## REPORT UPDATE

Application No: LU/269/15/HH

**LOCATION:** 95 Griffin Crescent  
Littlehampton

**PROPOSAL:** 2 storey side extension & dormer in rear roof slope. This application may be determined by Littlehampton Town Council under delegated powers

PROPOSED FRONT ELEVATION

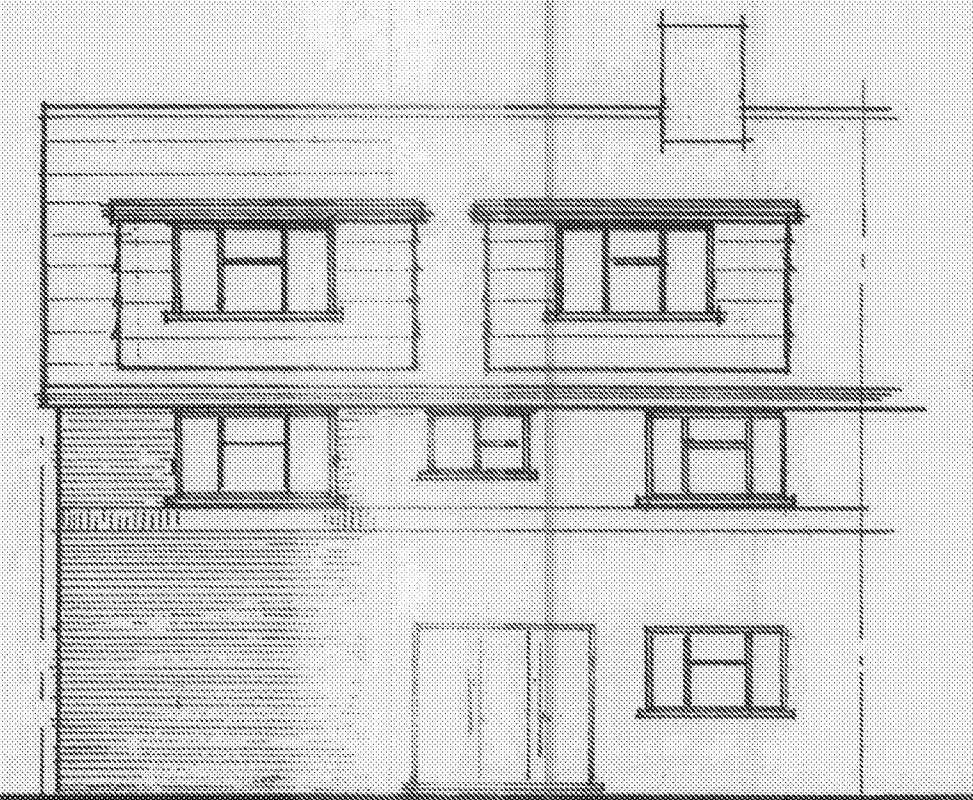
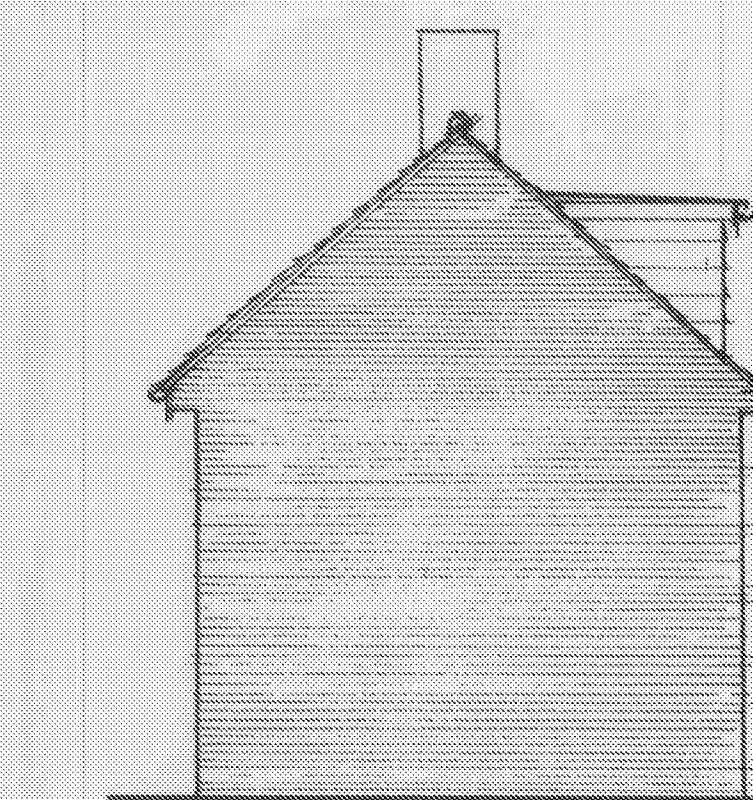
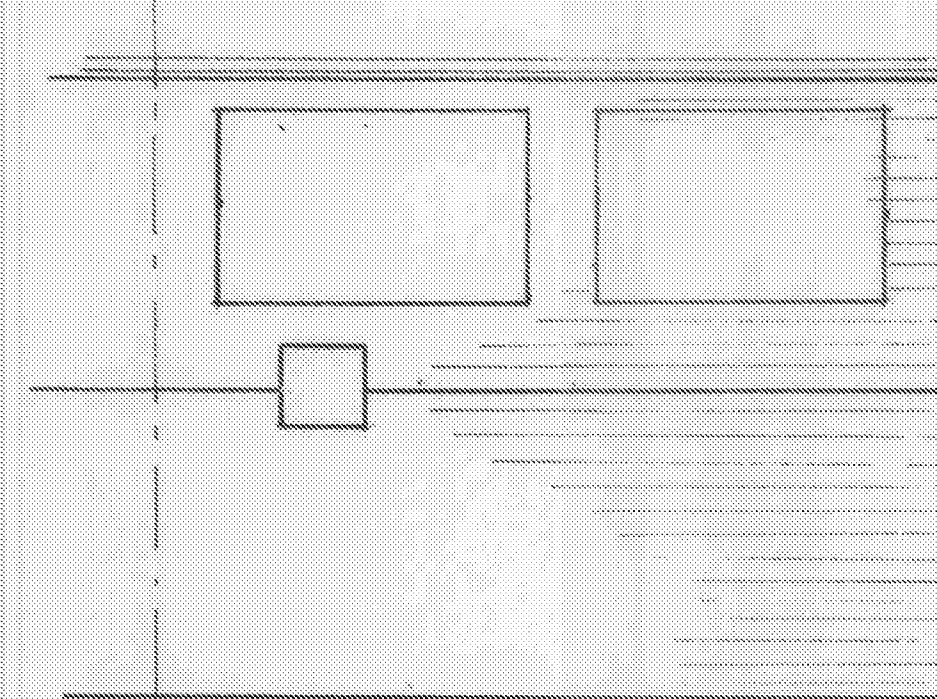
Officers Comment: The proposed scheme has been amended with the gable end having been altered and replaced by a hipped roof which will match in design and appearance that already present at the dwelling. Therefore, the proposal is now considered to comply with relevant local development policies.

The proposal has been amended with the proposed gable end being omitted and the proposal now featuring a hipped roof in accordance with the established character of the area.

The proposed two storey side extension therefore considered to appear subservient and well integrated with the existing dwelling and as such is deemed to be in accordance with policies GEN7 (ii) and DEV19 (i), (ii) & (v) of the Arun District Local Plan.

The proposed dormer on the rear elevation of the property is considered to be acceptable and due to its position and scale will appear subservient and well integrated with the host dwelling in accordance with policies GEN7 (ii) and DEV19 (i) & (ii) of the Arun District Local Plan.

The proposed rear dormer by virtue of its design and location is not considered to give rise to any overbearing or overshadowing impacts. The dormer is located 25m from the rear boundary of the site and as such will not give rise to any unacceptable overlooking of adjoining residential properties. Therefore, the proposed dormers are considered to be in accordance with GEN7 (iv) and DEV19 (iii) of the Arun District Local Plan.
